About the application

Application number: 2023/91459	
What is the application for?:	Erection of extension and associated alterations
Address of the site or building:	268, Halifax Road, Hightown, Liversedge, WF15 6NP
Postcode:	WF15 6NP

Proposed block plan (1:500)

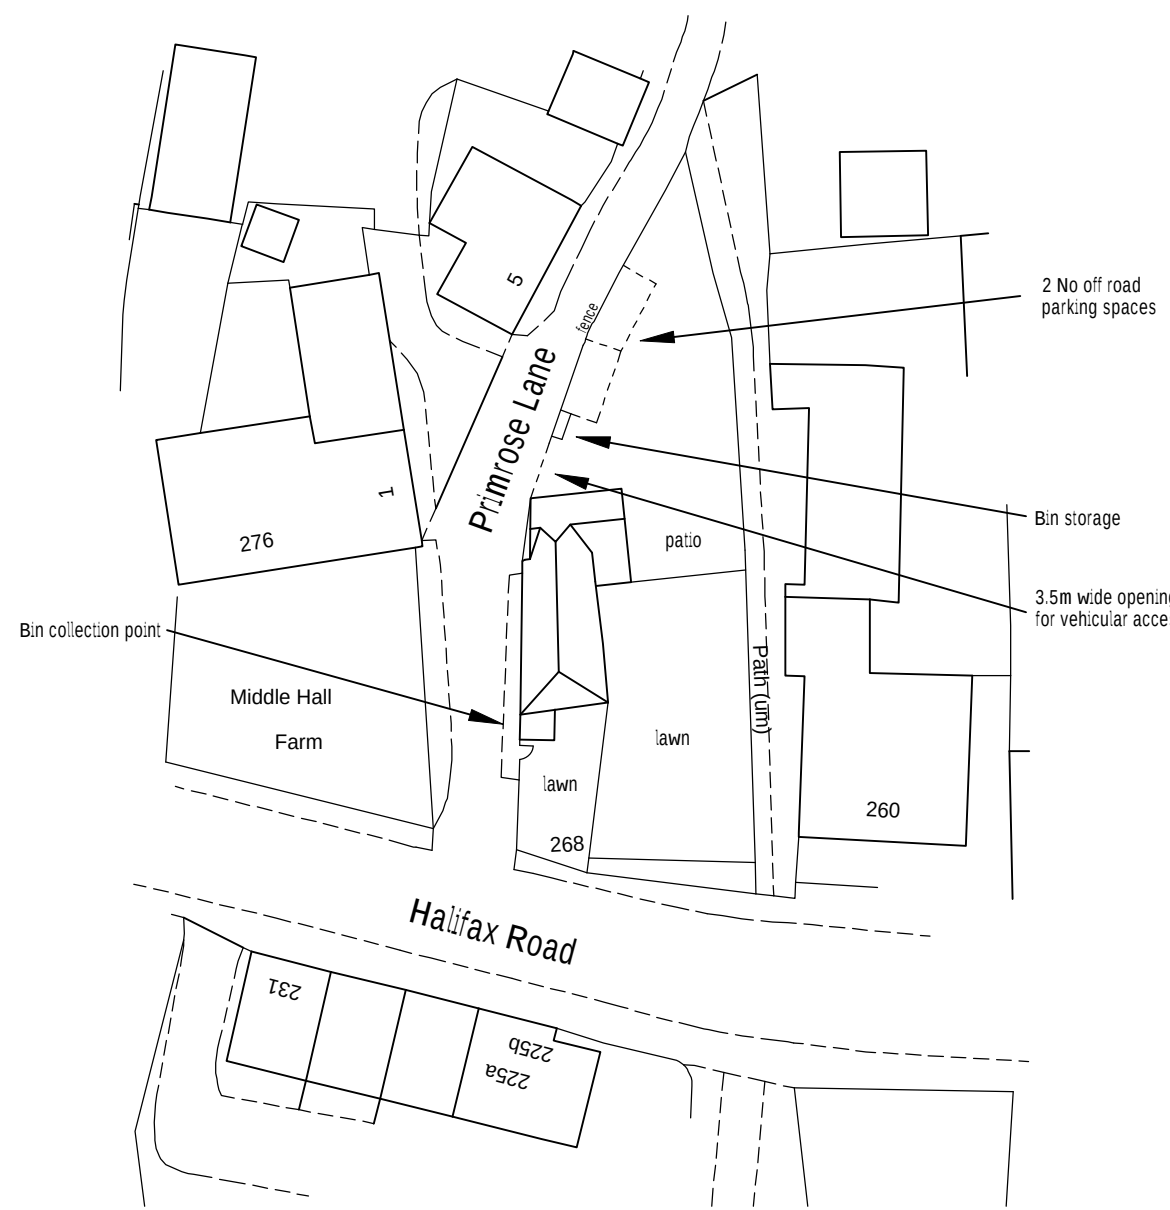
Type of comment: An objection	
Do you wish your comments to be published on the website anonymously?	Yes
I do not consider the amendments address any points on my previous objection, therefore believe this application should be rejected. I have set out below my objections. 1. The access for the parking is now shown on the plans and affirms my concerns. The extension will impede the view for pedestrians and horseback riders as well as cars coming in and out of the access down primrose lane, presenting a danger to the bridleway users. With this being a bridleway, priority should be given to the pedestrians and horseback users safety. 2. The application sets out to build on the boundary line to the land to the east of the current dwelling. This land used to have a Kirklees No Ball Games sign on the land which can be seen from Google Maps, yet this has now been removed and a fence has been placed around the land. I do not believe the applicants own the land, there this should be checked. 3. The proposal of the window in bedroom 3 overlooking 260 Halifax Road appears to face directly into another window. According to the Kirklees Local plan, privacy should be protected for surrounding residents 4. I've noticed that from previous applications, the location plan provided outlining the boundary has changed somewhat. The previous owners who submitted an application in 1995 for the porch didn't outline the path or access from primrose lane, the initial application in 2021 by the current owners shows the path and most of the access off primrose lane, the submission for alterations then includes the access, then as part of the most recent submission in 2023 the location plan boundary has been drawn to include the toilet block facing onto the land that was previously occupied by the kirklees sign. I find this highly suspicious with so many changes to the plans. This should be checked.
